From: Martyn White <Martyn.White@arun.gov.uk>
Sent: 01 December 2020 17:50
To: Andrew Wood <Andrew.Wood@arun.gov.uk>
Subject: CM/32/20/PL

CM/32/20/PL

Land adjacent to Church Farm Barn, Horsemere Green Lane, BN17 5QZ

Change of use of land (B Storage) & erection of 1 No. detached single storey, two bedroom dwelling. This application affects the setting of a listed building & is a Departure from the Development Plan

PROPOSED BUNGALOW –
ELEVATIONS (1)

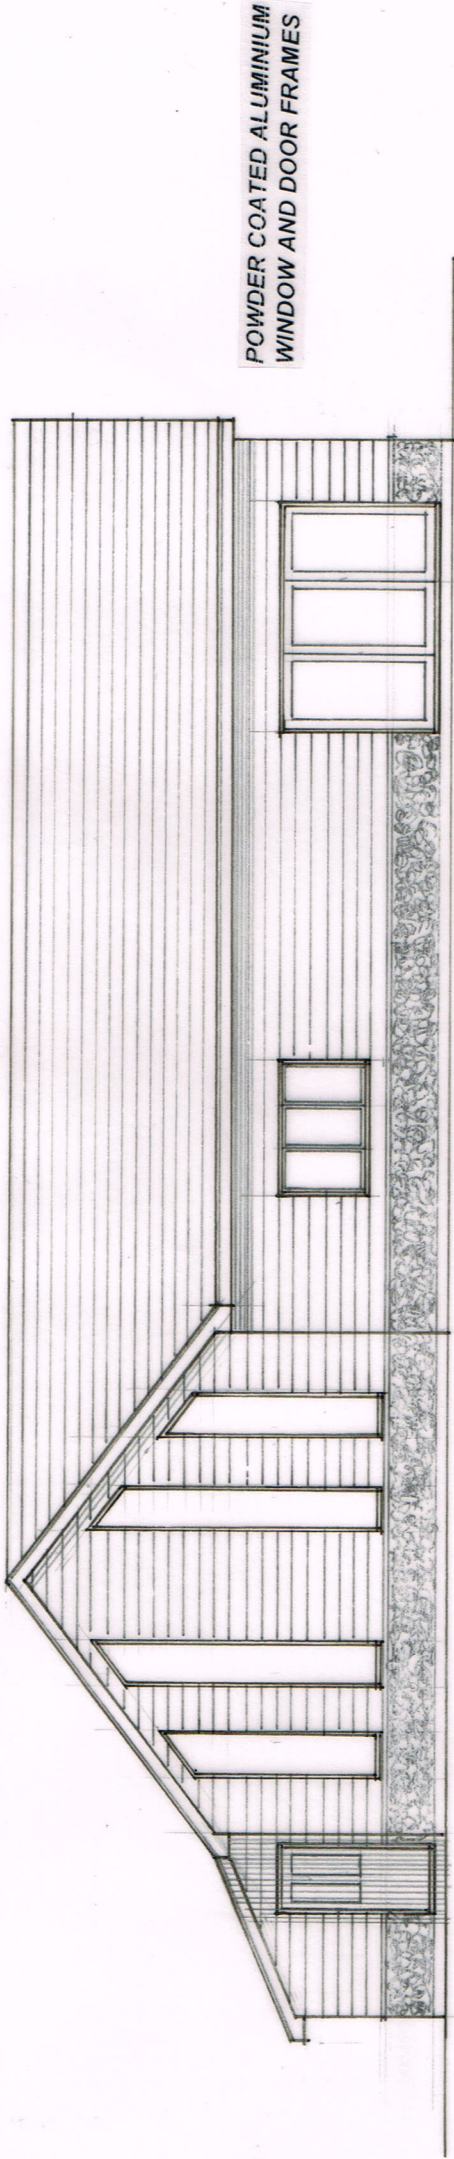
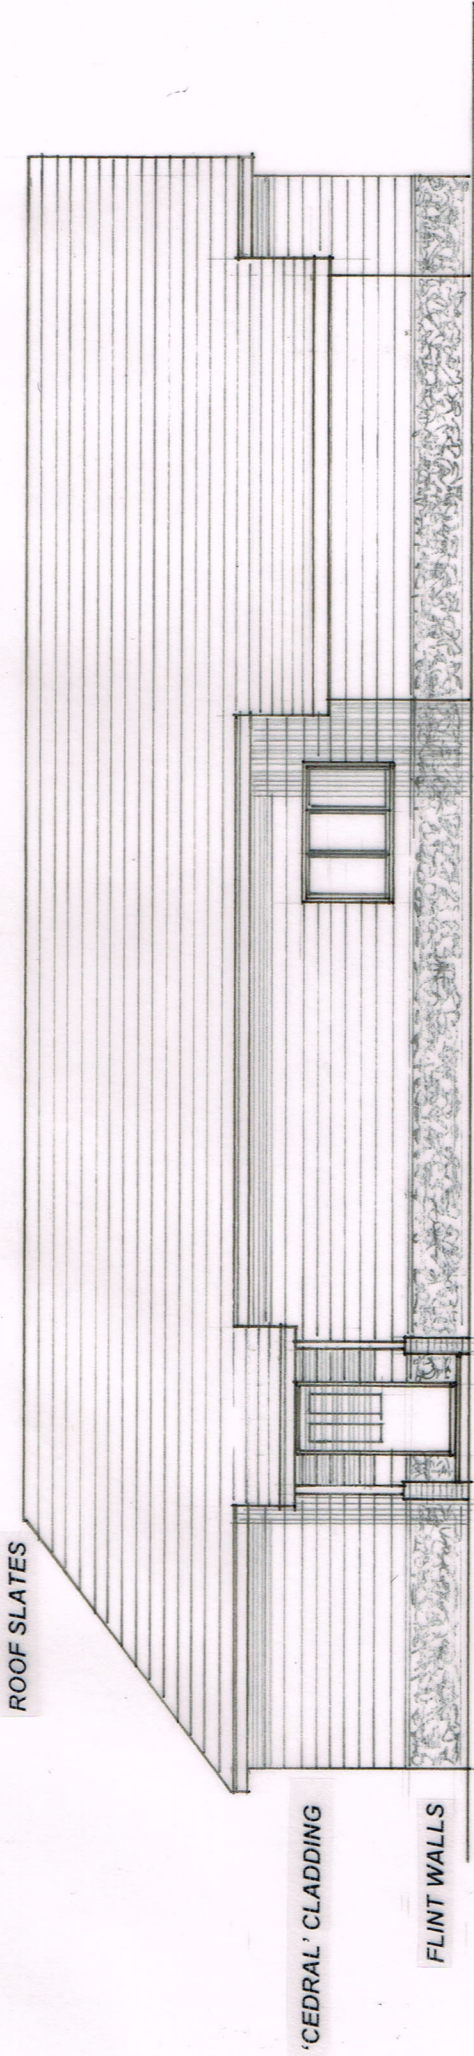
The application site is already used for storage of vehicles etc. but screened from the road by a mixture of vegetation and modern fencing. Whilst the change of use may be acceptable as it will introduce a more suitable use in the lane, I am concerned about the design of the proposed dwelling which, whilst attempting to be of agricultural character, is to be designed and clad in materials not traditionally associated with either the neighbouring listed barn or the more traditional buildings in the local area.

The neighbourhood plan character assessment (prepared as part of the Neighbourhood Plan) identifies that the lane is located within an area it refers to as 'traditional Climping'. Of note is the fact that the assessment for this character type states: "Much of the construction is traditional rural with pitched roofs of slate tiles or of thatch, some timber framing, and flint or rendered walls". There is no reference to cladding, and it does not appear to be identified on the main elevation of the listed barn. The use of the cladding on all of the elevations, especially one of modern construction is out of character with the buildings in the local area, as well as the listed building. Further, the fenestration on the South-West elevation is not reflective of the intended barn character and is therefore problematic. It is suggested that an alternative approach is considered which will better reflect the character of the area and complement the neighbouring listed barn.
